**Notice of Exhibition of application for Powerhouse Ultimo Renewal (SSD-32927319)**

Thank you for your referral dated 15 June 2022 inviting comments from the Heritage Council of NSW on the above State Significant Development (SSD) proposal.

The proposed SSD affects the State Heritage Register (SHR) items, Ultimo Powerhouse (SHR no 02045) and former Ultimo Post Office buildings (SHR No 00502).

Figure 2 3D view of the proposed maximum building envelope

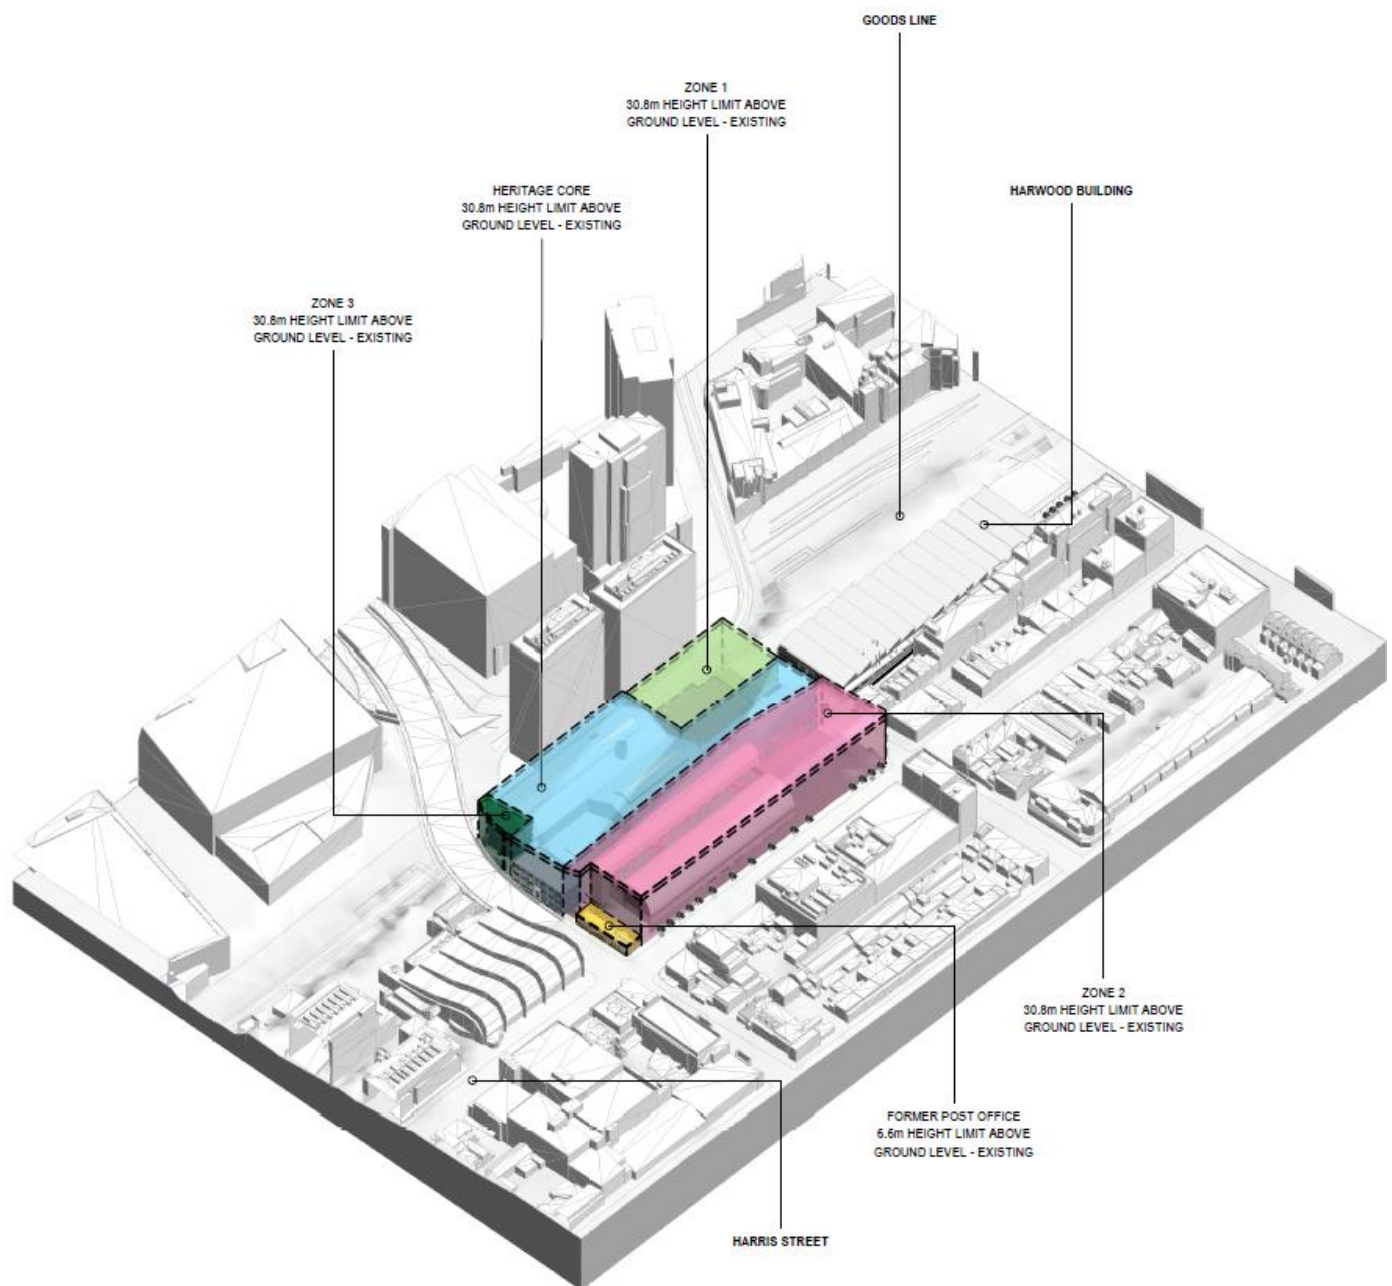
- The documentation clearly states due to the presence of significant heritage buildings, a **maximum building envelope** would not be achievable across the entire site. Therefore, it is unclear why consent is sought for a blanket maximum building height envelope across the entire site. It is recommended that the maximum building height envelope be restricted to areas where the new development is envisaged. This would ensure that the curtilage and forms of the state listed elements within the project site are best protected.

- Any additional building height under the provisions of **4.6 clause variation** requires further consideration. As mentioned above, it is desirable that any extension of the building height envelope above the extant state listed buildings be deleted to ensure that the buildings retain historic roof planes and forms, as an initial premise.
